August 4, 2015

Re: Response to Permit Review Comments, BP#2015-01369 767 Congress St.

Response to Comments:

Sheet Number: A3.1

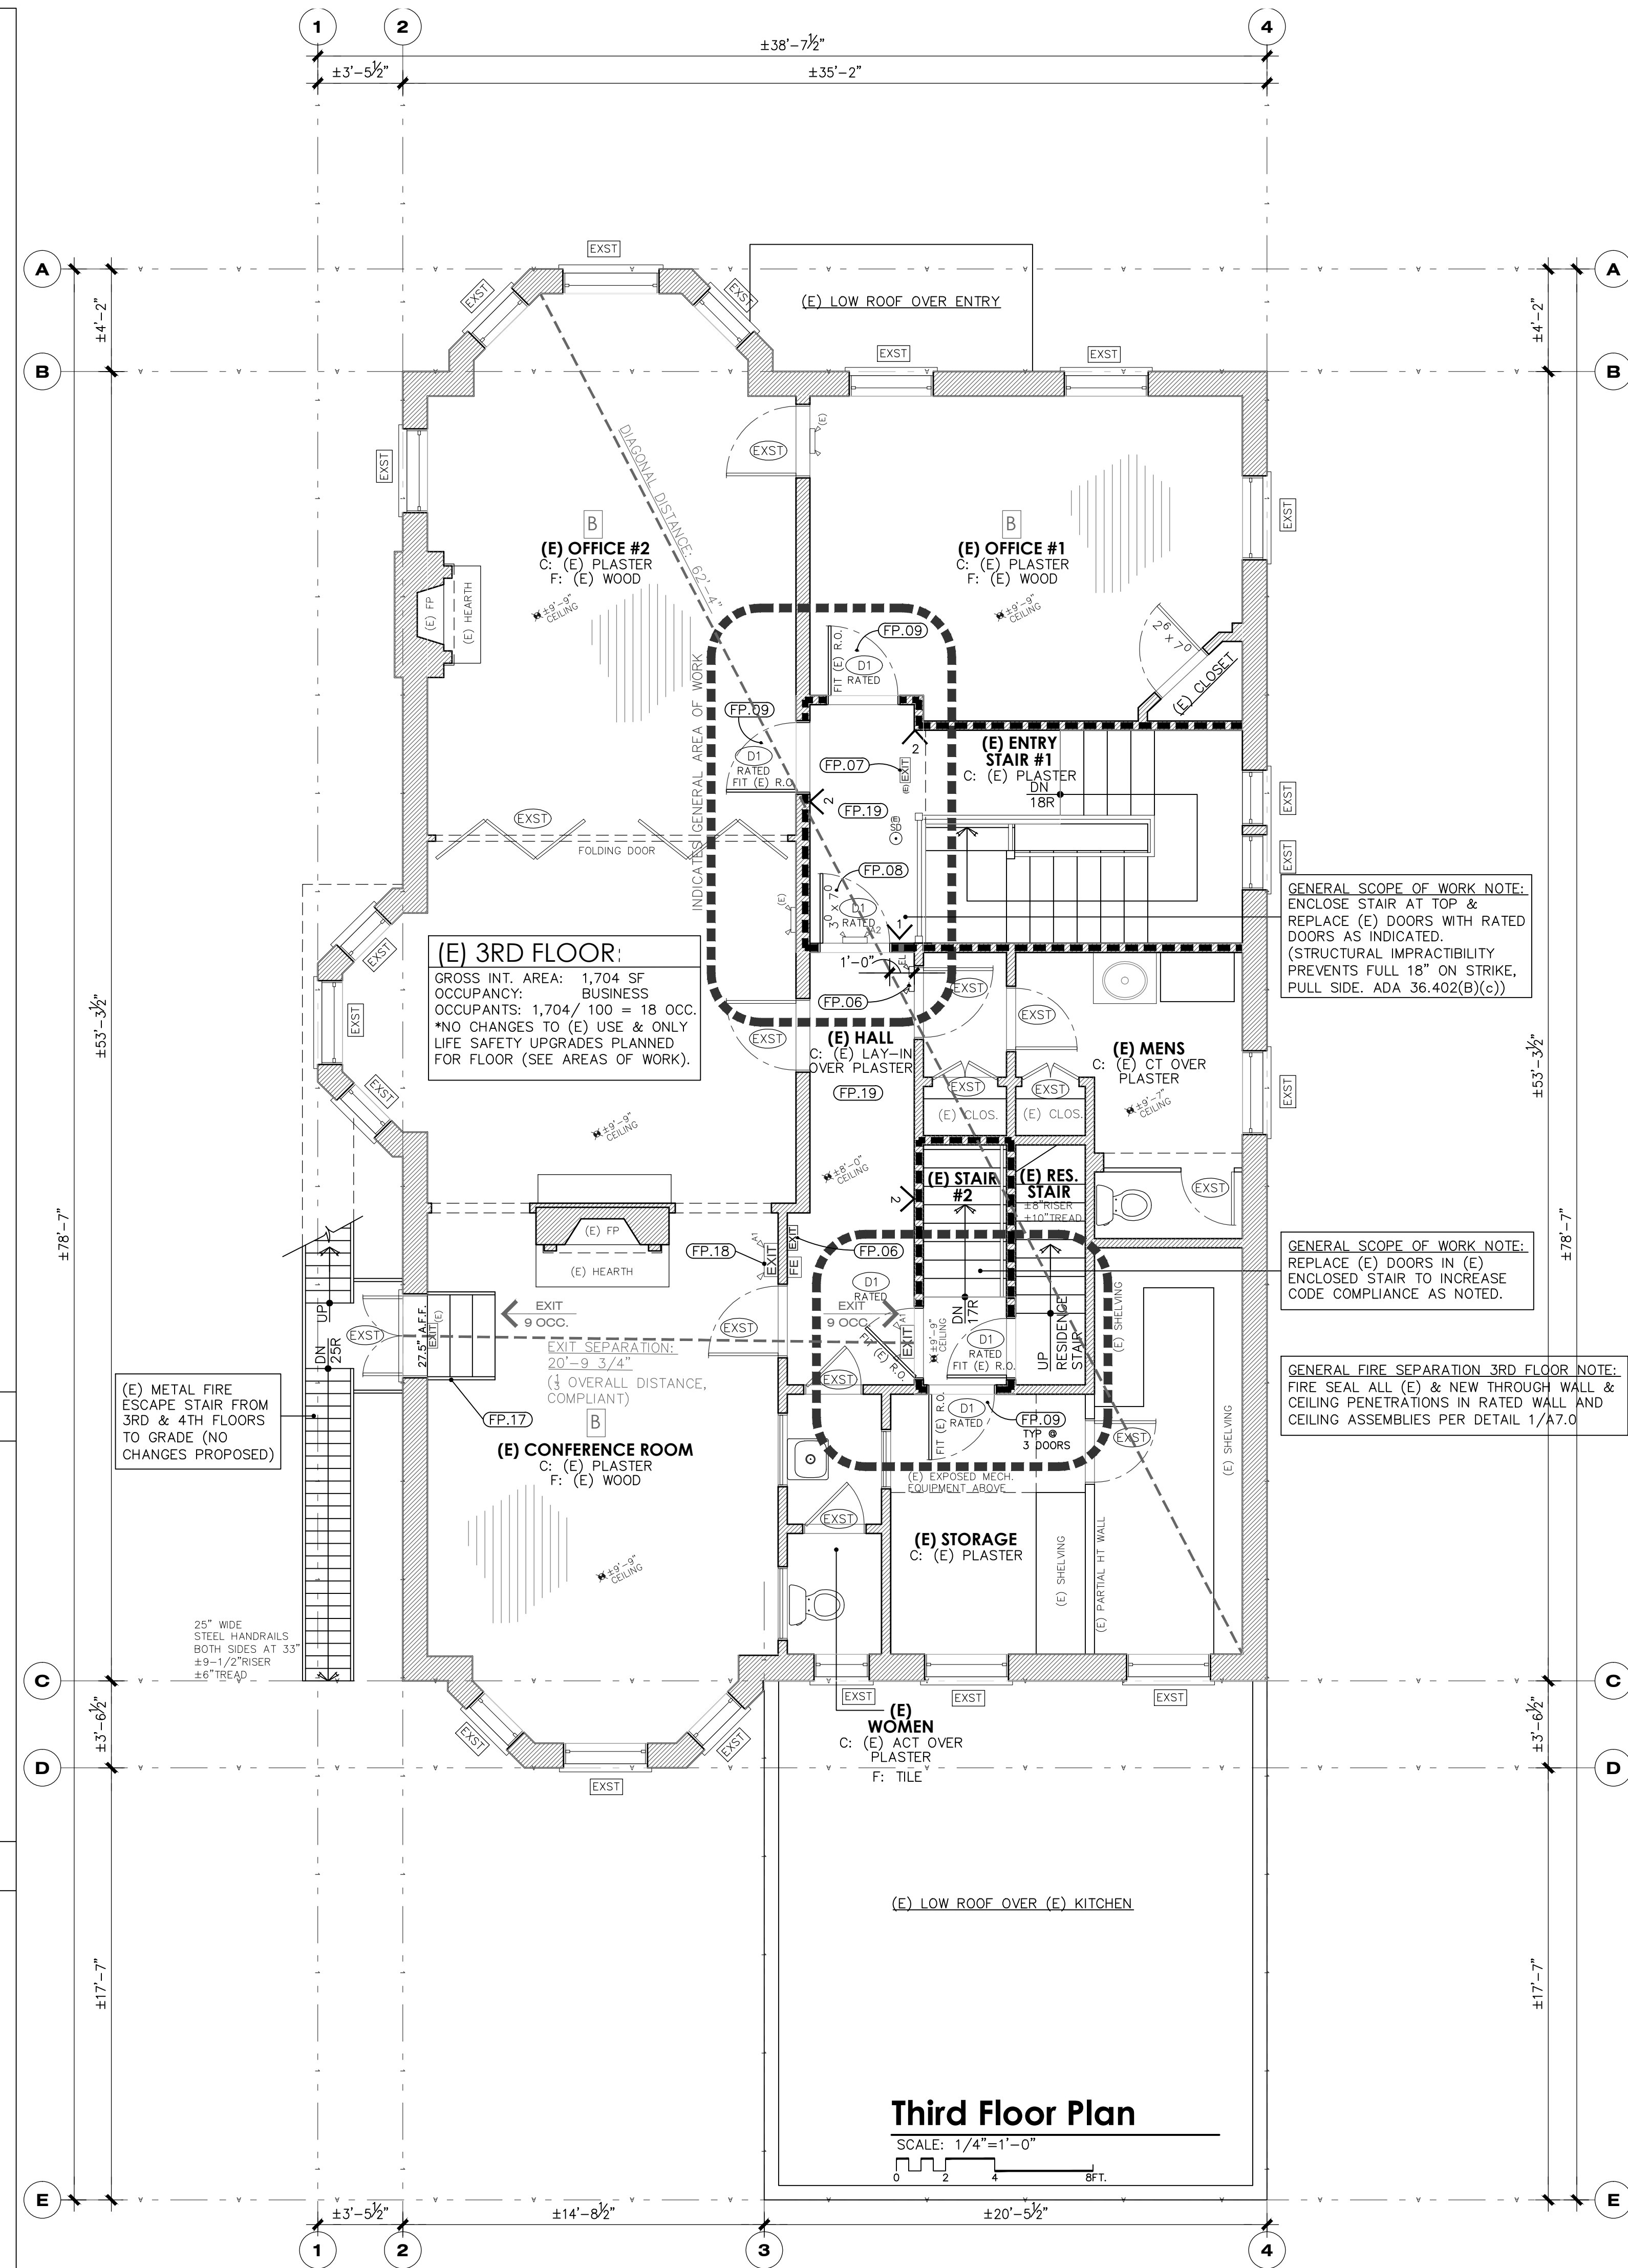
- **Comment:** *"The solid dashed lines on this plan sheet are very similar and difficult to differentiate. Also, the key does not provide the representation of an existing wall with separation. Please alter key plan to help clarify."*
  - **Response:** The key plan has been modified to reflect both new and existing fire-rated wall construction. Please also note that the wall symbols provide a description of the wall construction for new and existing walls in the project work area.

6 Existing Ceiling/Wall Intersection
SCALE: 3/8"=1'-0"

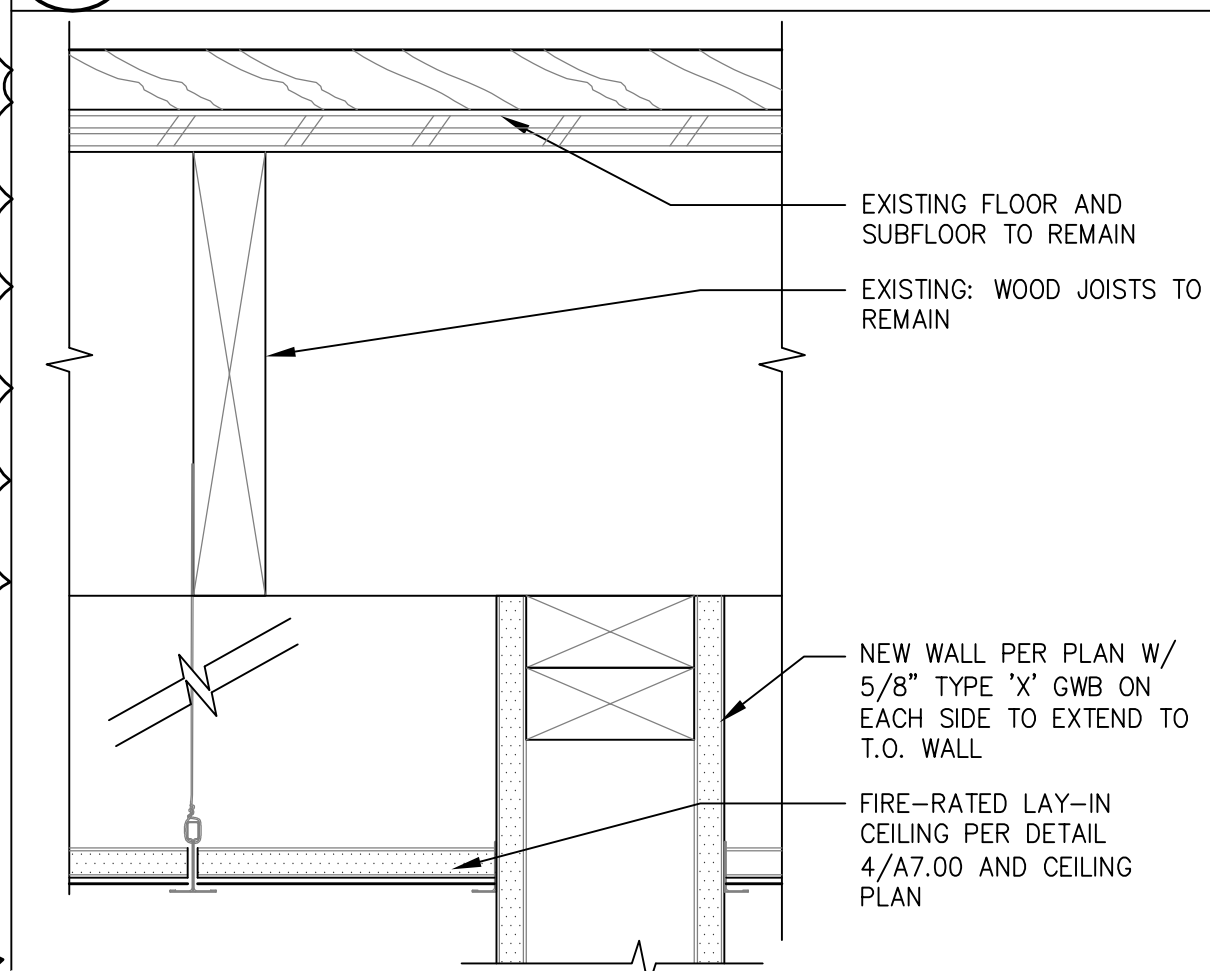
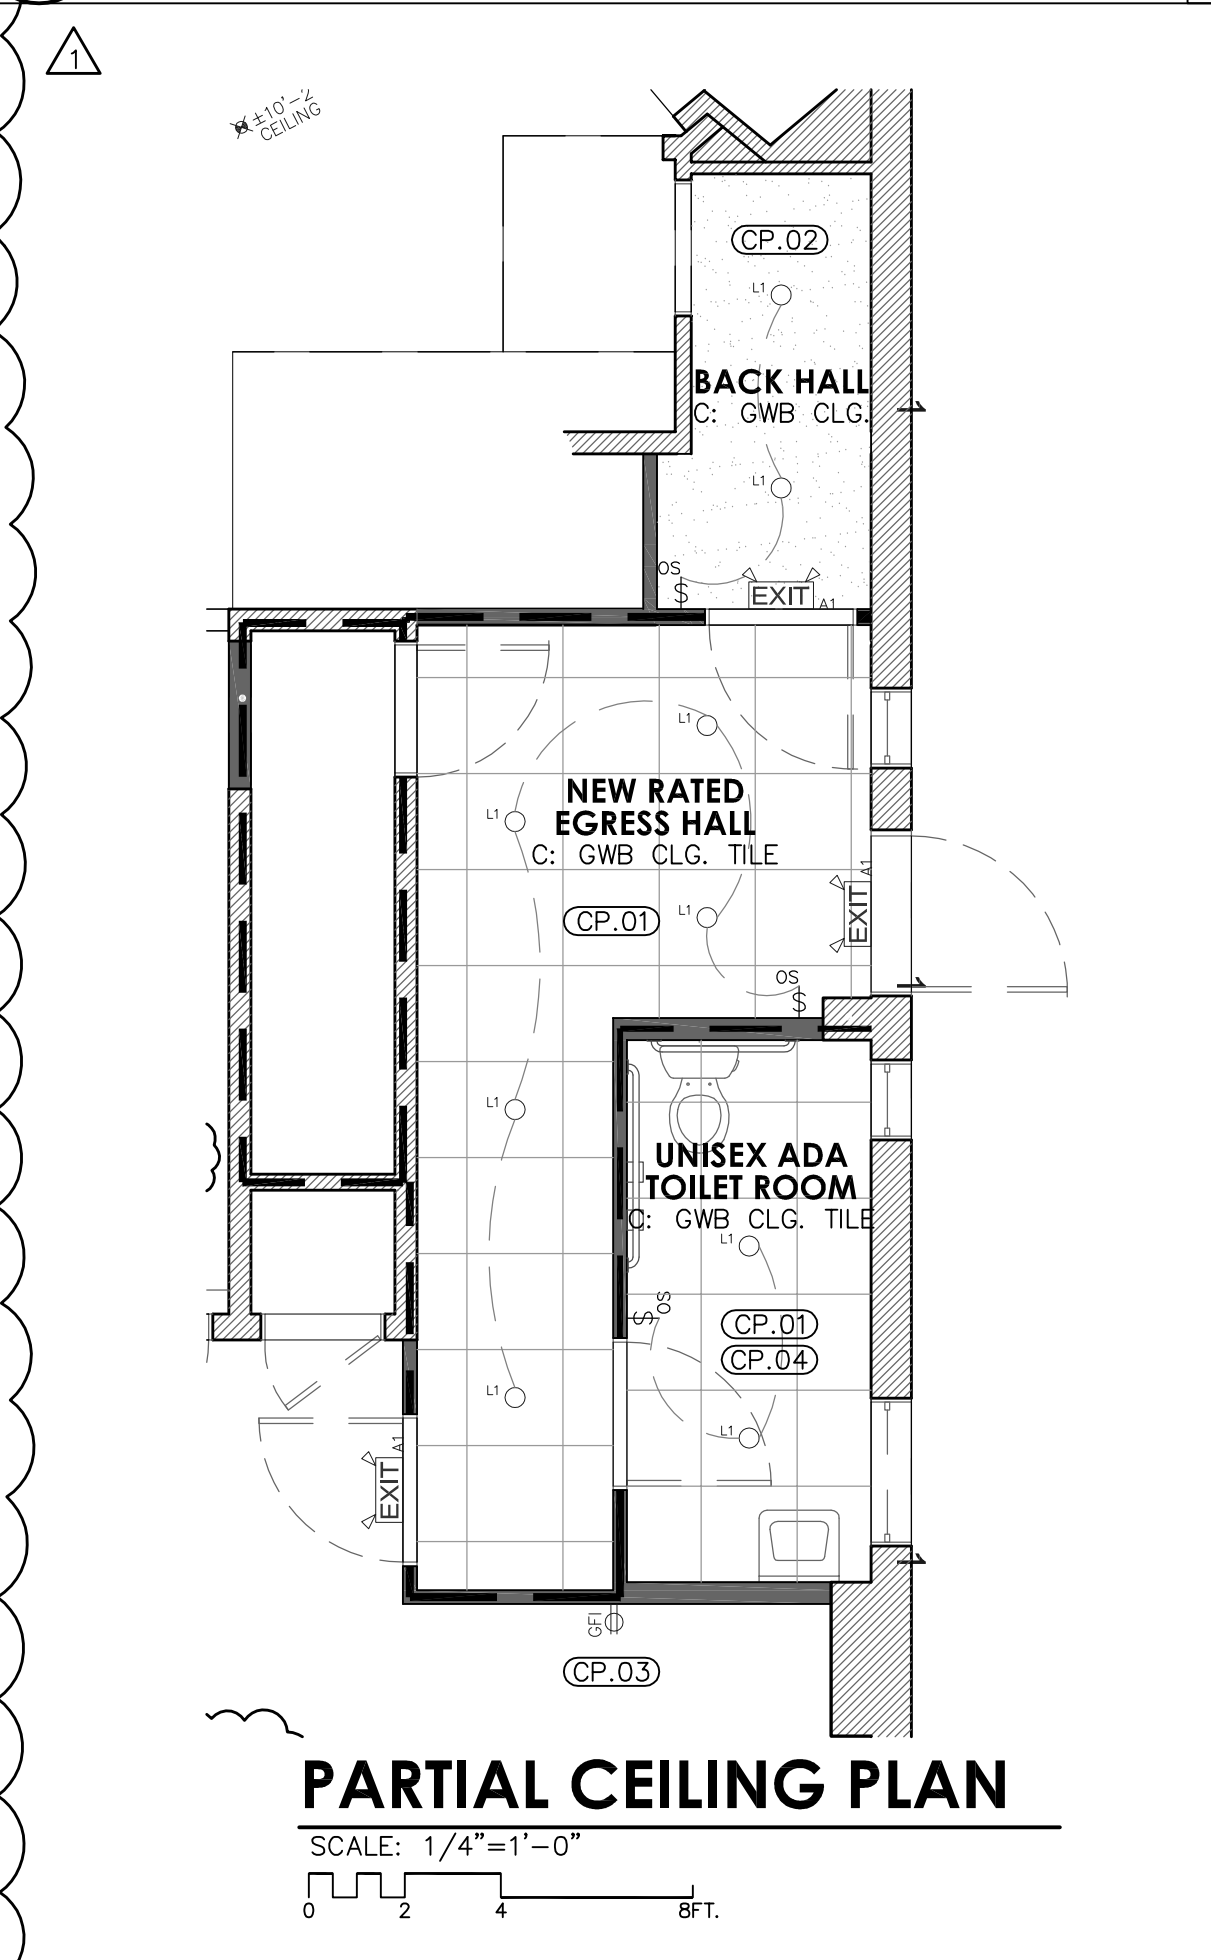
- **Comment:** *"Provide wall detail and head of wall section showing continuity of separation."*
  - **Response:** See details 6/A7.0 (existing wall/ceiling intersection) and 7/A7.0 (new or existing ceiling intersection at new wall.)
